DOC22/596258-12

EPA Comments on Environmental Impact Statement

Thank you for the referral to the Environment Protection Authority (EPA) requesting comment on the Environmental Impact Statement (EIS) for State Significant Development (SSD) application no.SSD-11606719.

The EIS has been prepared by Arcadis Australia Pacific Pty Limited on behalf of Dial-A-Dump Pty Ltd (the Proponent) for the proposed Eastern Creek Recycling Ecology Park Throughput Increase at Lot 1 DP 1145808, Lot 2 DP 1247691, and part Lot 2 DP 1145808, also known as 1 Kangaroo Avenue, Eastern Creek, NSW, 2766 (the Premises).

1 GROUND MAINTENANCE & MANUFACTURING 1 : 400

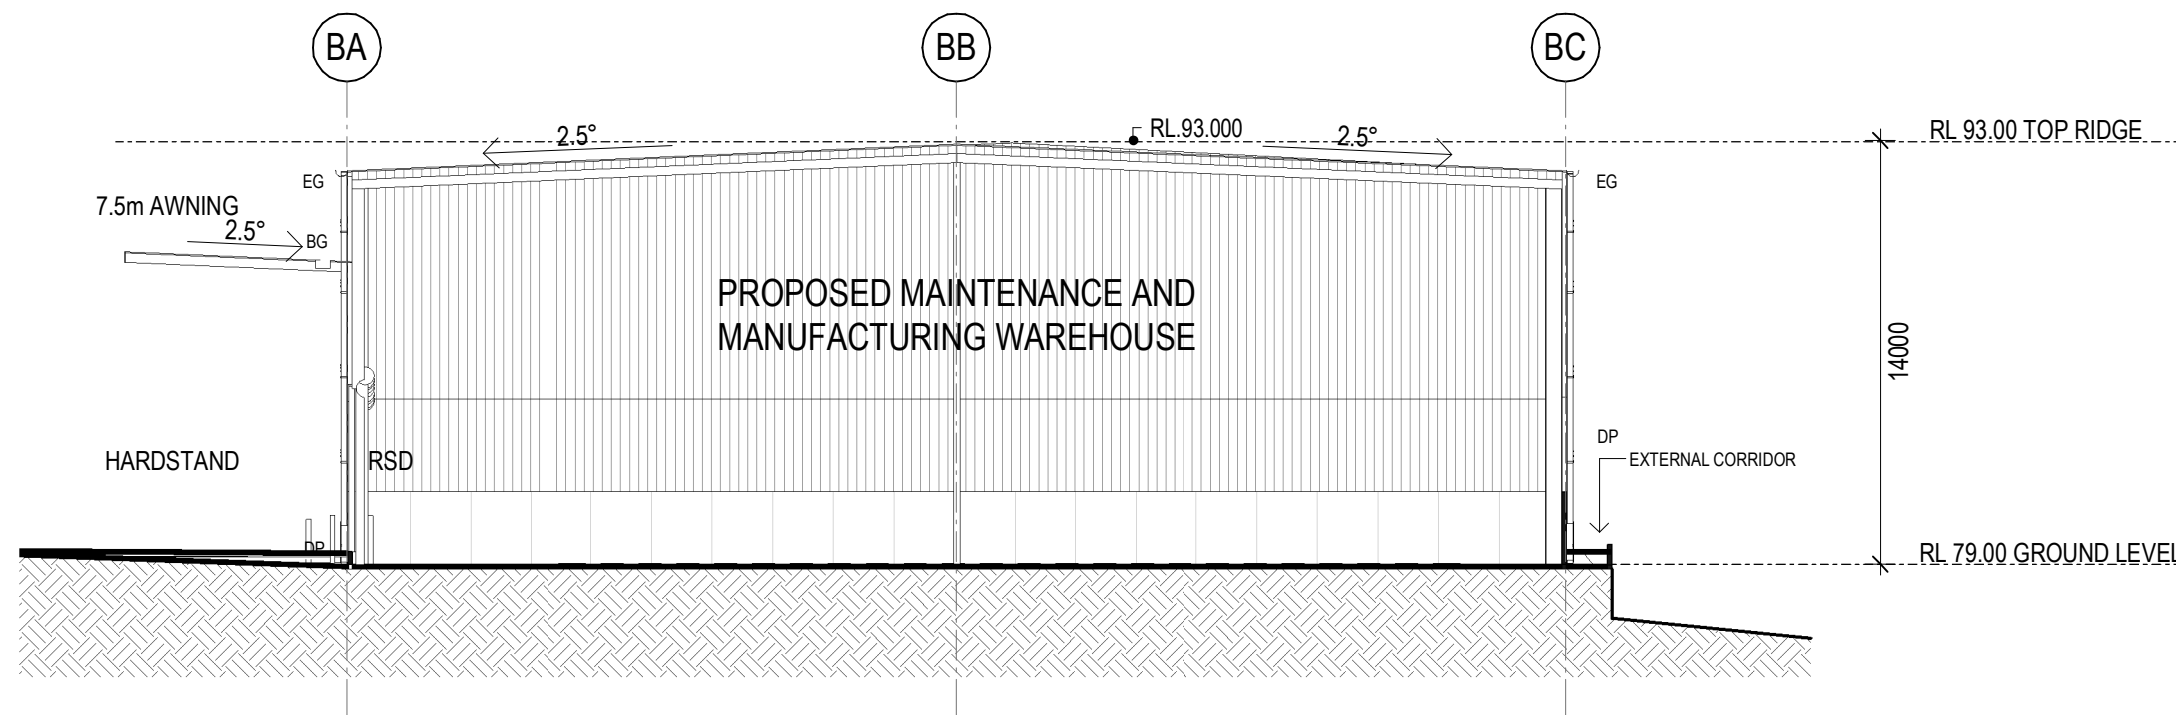
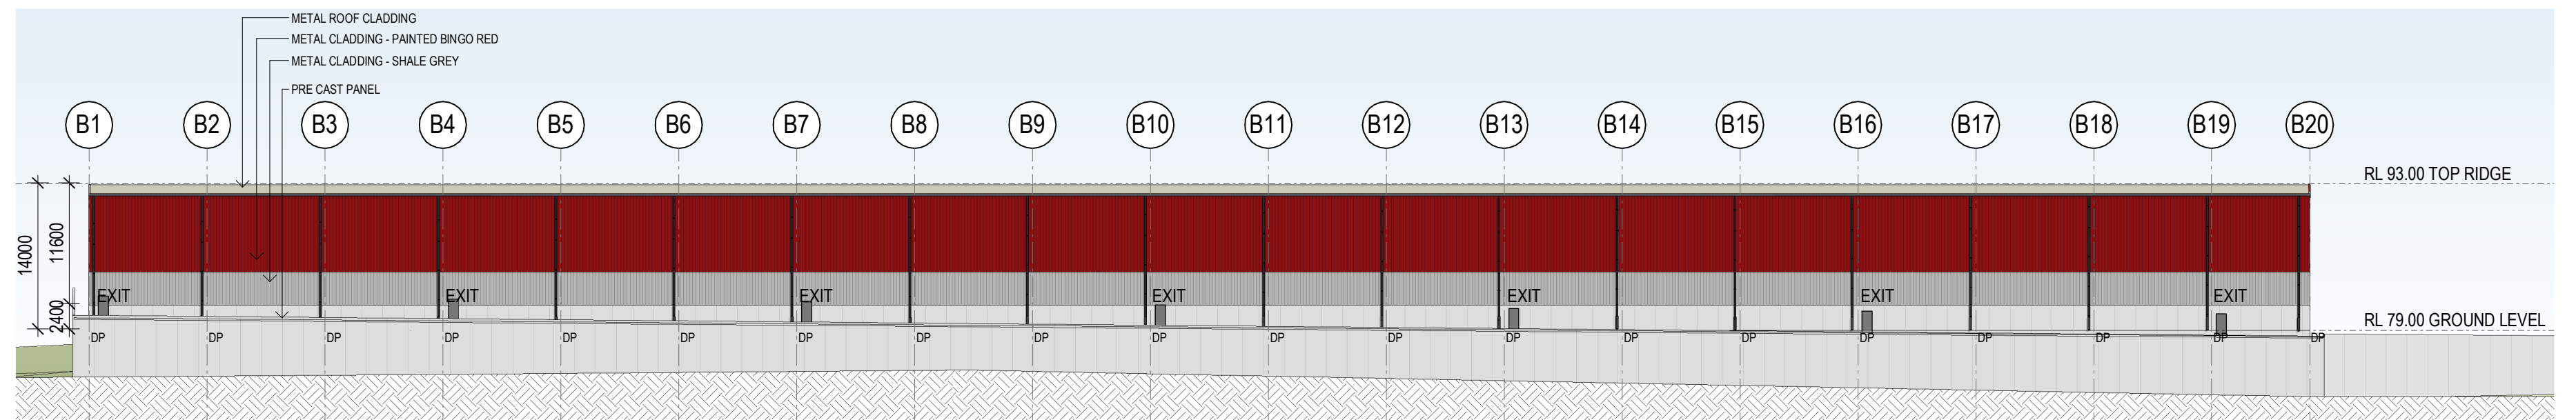
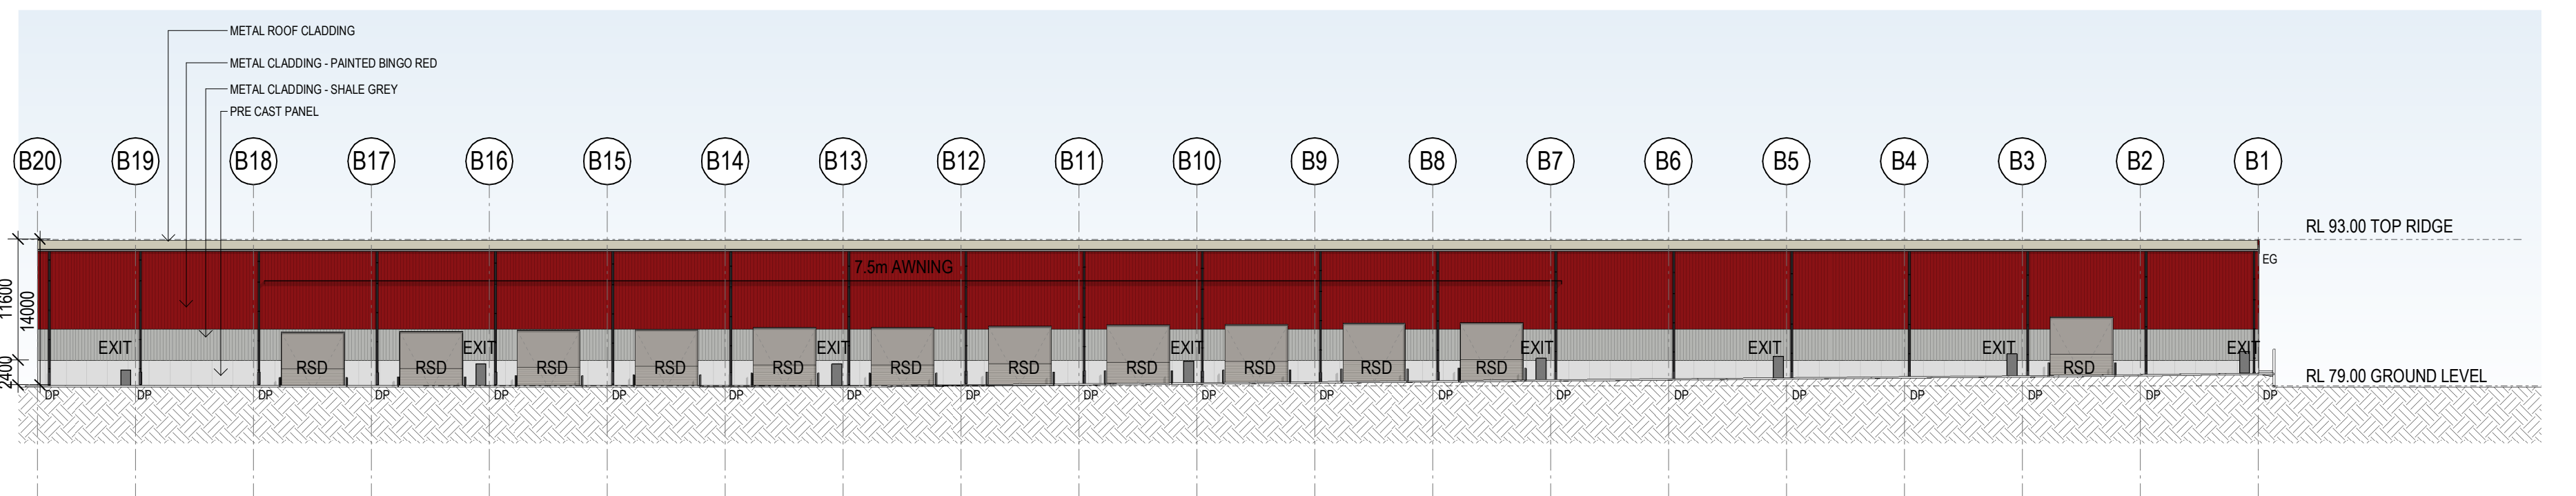
The new maintenance and manufacturing workshops proposed as part of stage 3 of the Proposal include a skip bin manufacturing and maintenance facility. However, it is not clear how the NVIA has

considered the potential impact noise from the handling, maintenance and storage of skip bins, which have the potential to cause noise events at receivers, particularly as the proposed workshops are intended to operate 24 hours a day.

Skip bins, particularly empty bins can create noise events from striking the ground, other skips bins, machinery and general handling, maintenance and storage activities. Noise from the handling and storage of skip bins has the potential to be noticeable at receivers and must be appropriately addressed.

- *Clarification as to how skip bin handling, maintenance and storage and other potential noise generating activities from skips bins was addressed in the NVIA.*
- *How the potential for L_{max} events and the influence on the Leq, 15min levels generated by skip bins related activities was considered in the NVIA. For example, did the assessment consider striking metal by tools, skip bins striking other objects, manufacturing activities, etc.*
- *The locations and areas where skip bins will be handled, worked on and stored, particularly in the new stage 3 workshop areas and hardstand, including if it will be indoors or outdoors.*
- *If any management measures or good practice methods are proposed to minimise the potential for noise events from skip bin activities to occur.*
